Detailed Highway and Environment Comments**Highway Comments****(a) Access Issues**

Figure 3.21 Construction Compound Options.

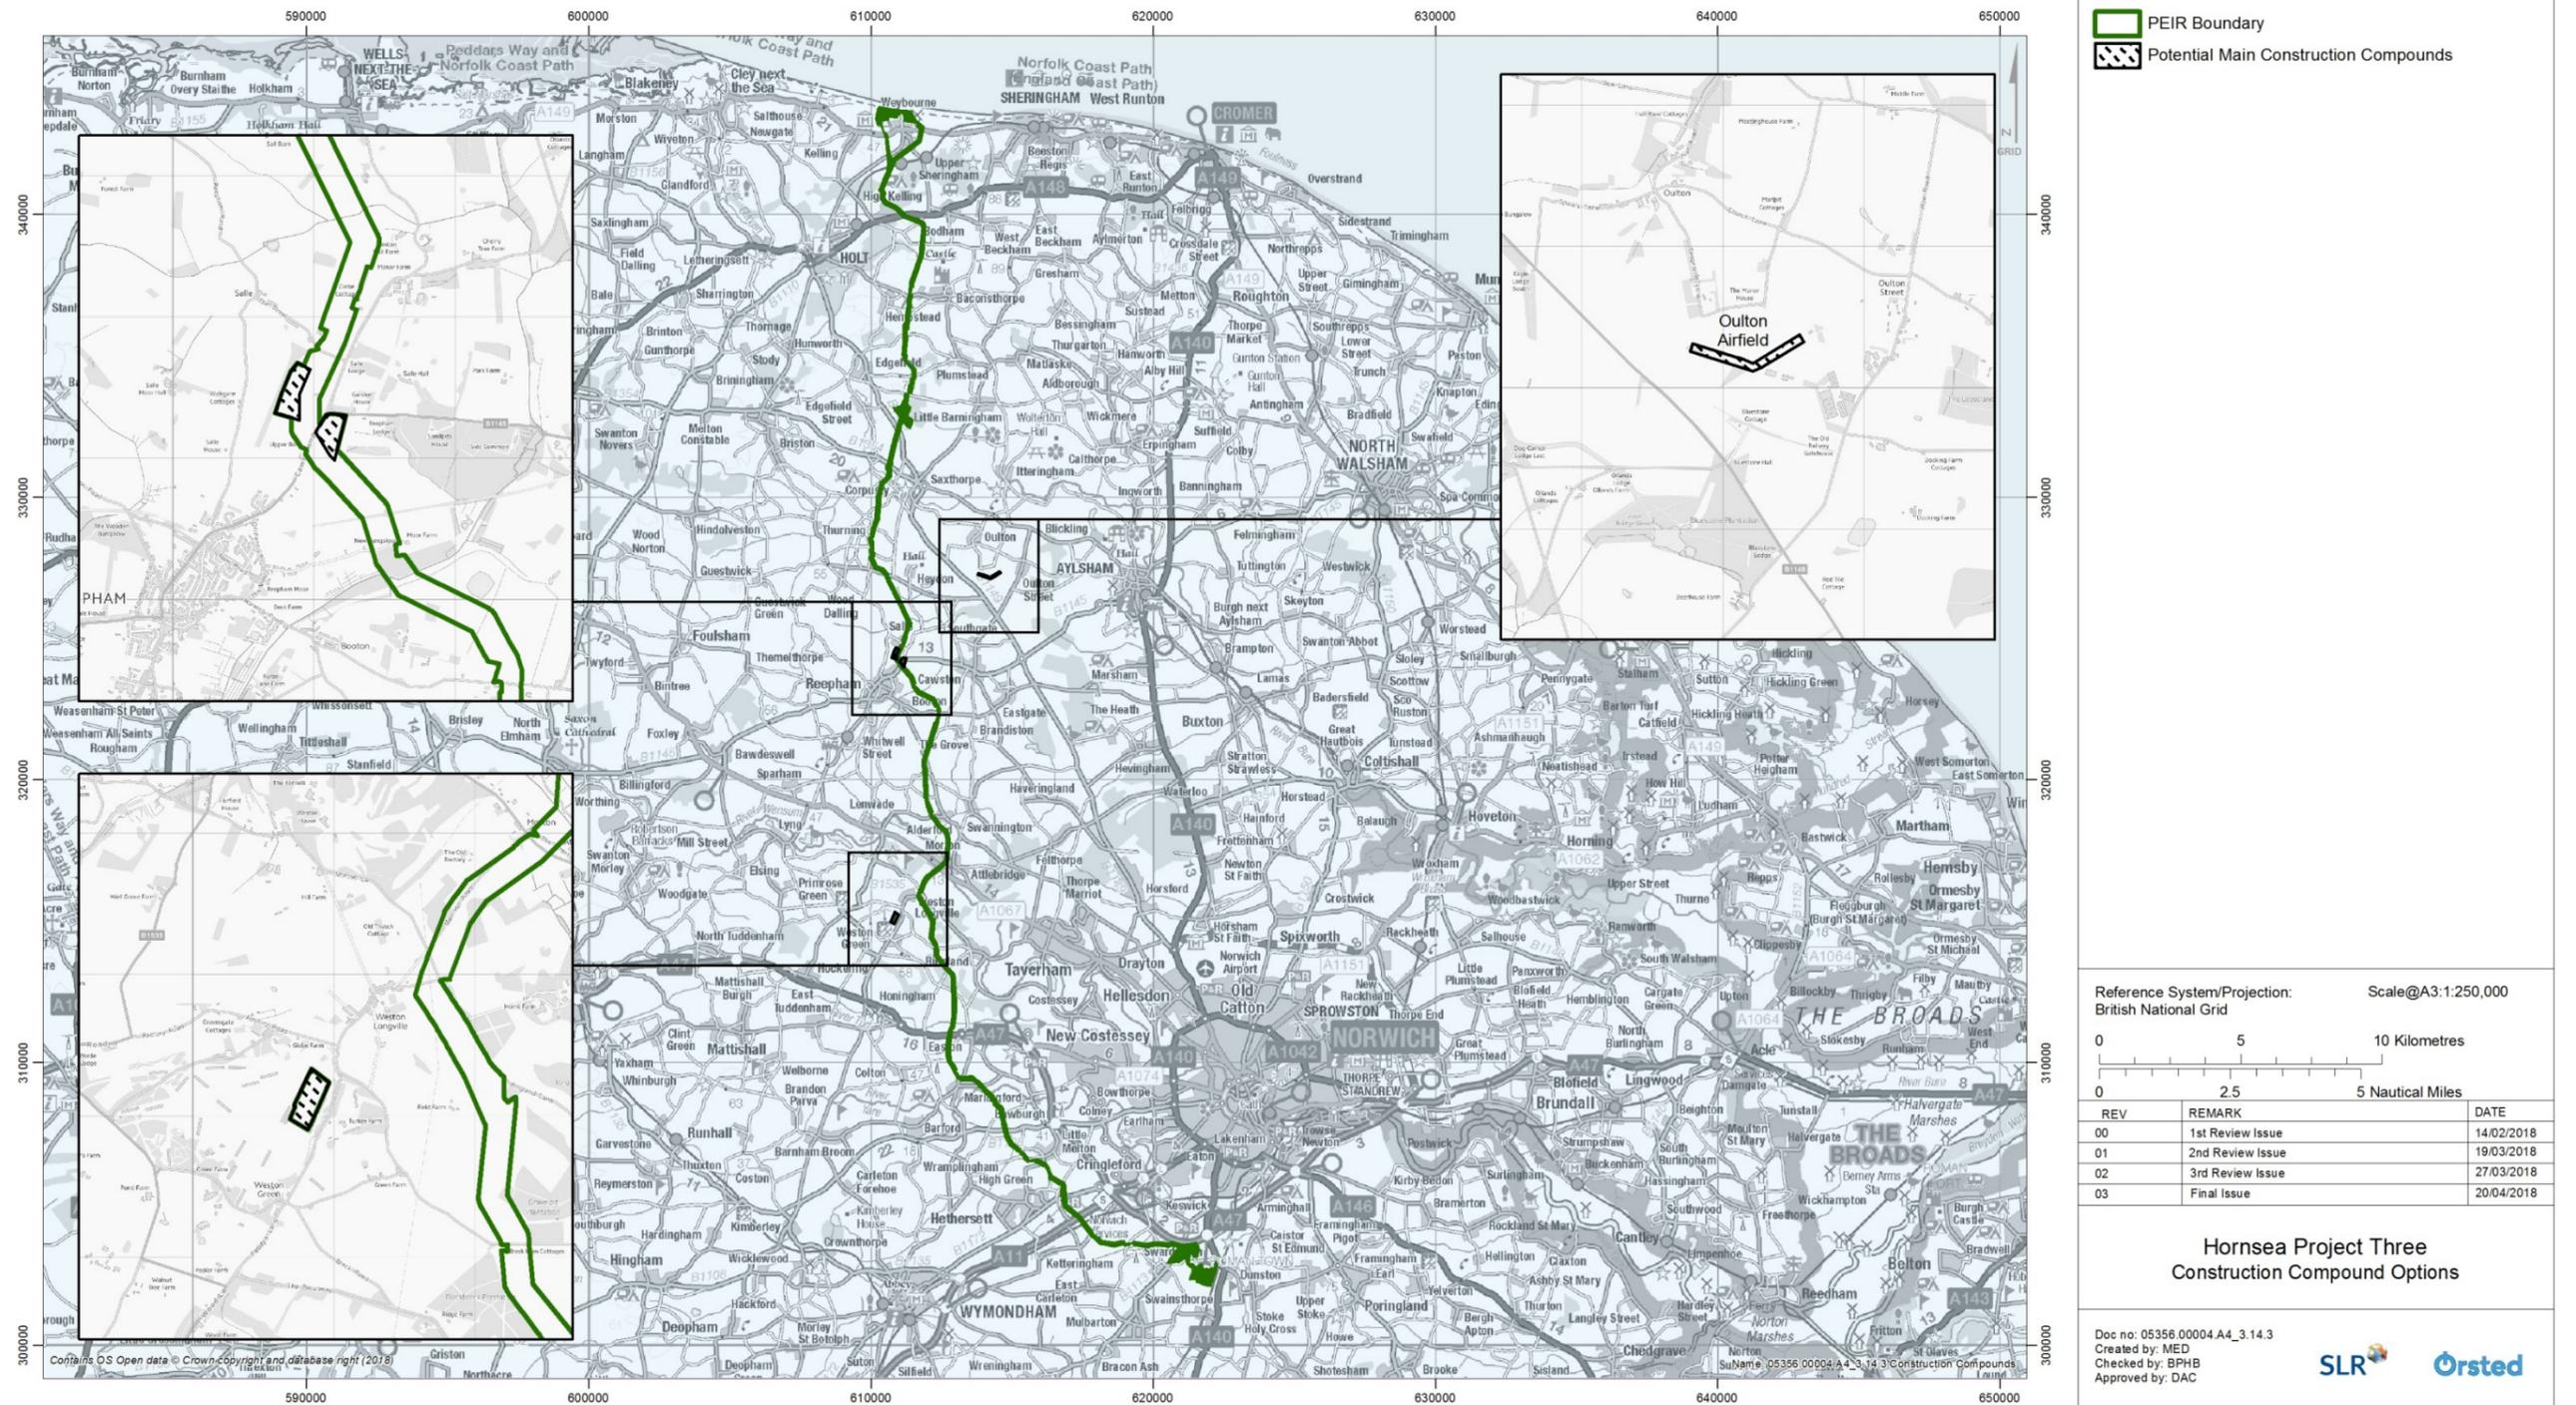
- 1.4. The main compound for the project is located at a completely different location to that included within the pre-application discussions. It is now located on the former Oulton Airfield and seeks to utilise an access and HGV route which the Planning Inspectorate identified in 2014 as being unsuitable for HGV's to use (PINS Appeal ref – APP/K2610/A/14/2212257).

- 1.5. **Comment –** it is felt that the applicant needs to find a different site for their main compound. However, if they wish to pursue their chosen site then they will need to:

- (i) provide a scheme of permanent off-site highway improvement works comprising carriageway widening along the entire route from the compound to the main road; and
- (ii) demonstrate that such a scheme is capable of overcoming the issues previously identified by PINS.

In the meantime it is felt that a **holding objection** on highway safety grounds should be raised to the inclusion of this site.

Figure 3.23: The Landfall at Weybourne.

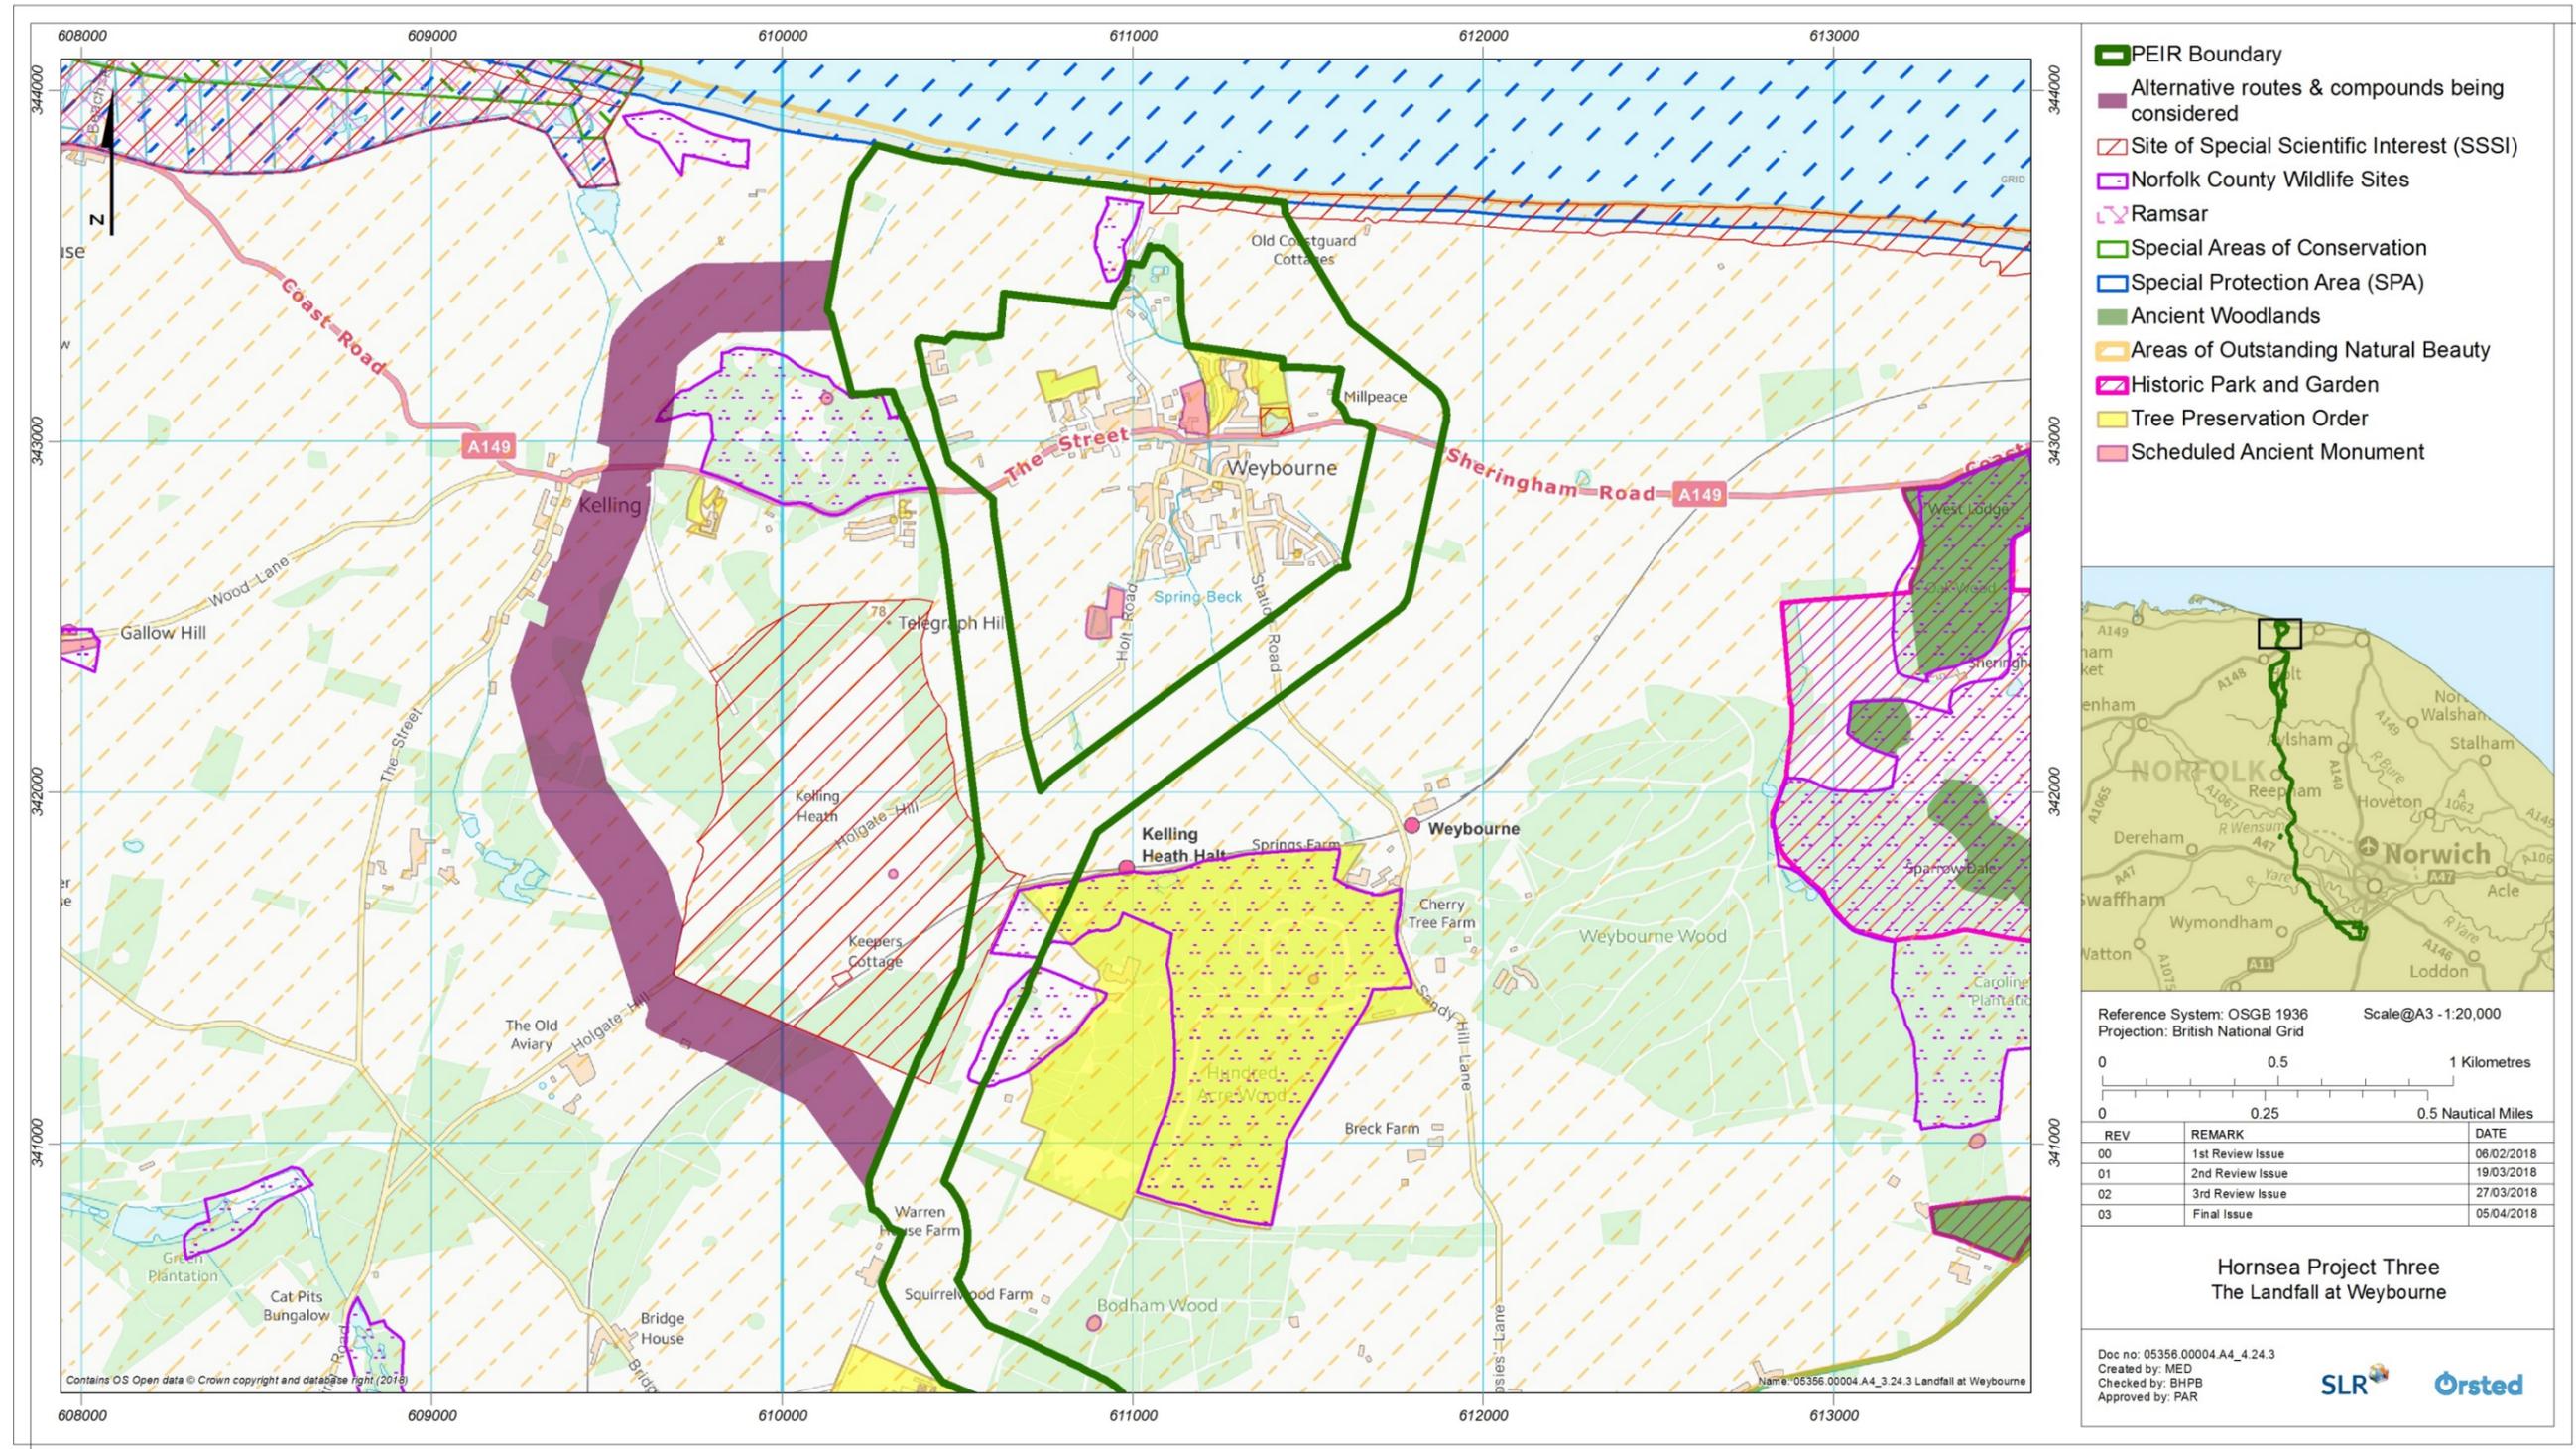
- 1.24. The location of greatest concern for NCC is the landfall location at Weybourne where there will be disruption to users of the Norfolk Coast Path. It is accepted that the documentation in the ES recognises the sensitive nature and high usage of the beach and the coastal footpath. The Draft CoCP states that in the event that access along the beach is to be restricted or the coastal path needs to be temporarily diverted, the principal contractor for the landfall works will “*submit a PRoW Management Plan to be approved by North Norfolk District Council as the relevant planning authority, developed in consultation with Norfolk County Council*”.

- 1.25. **Comment** - The Norfolk Trails Team have had some discussions with the Hornsea Three team on this matter but are yet to be convinced that the initial proposals for managing users of the Trail at Weybourne are workable. As such it is felt that Orsted should continue discussions with the County Council and an appropriate plan be drawn up.
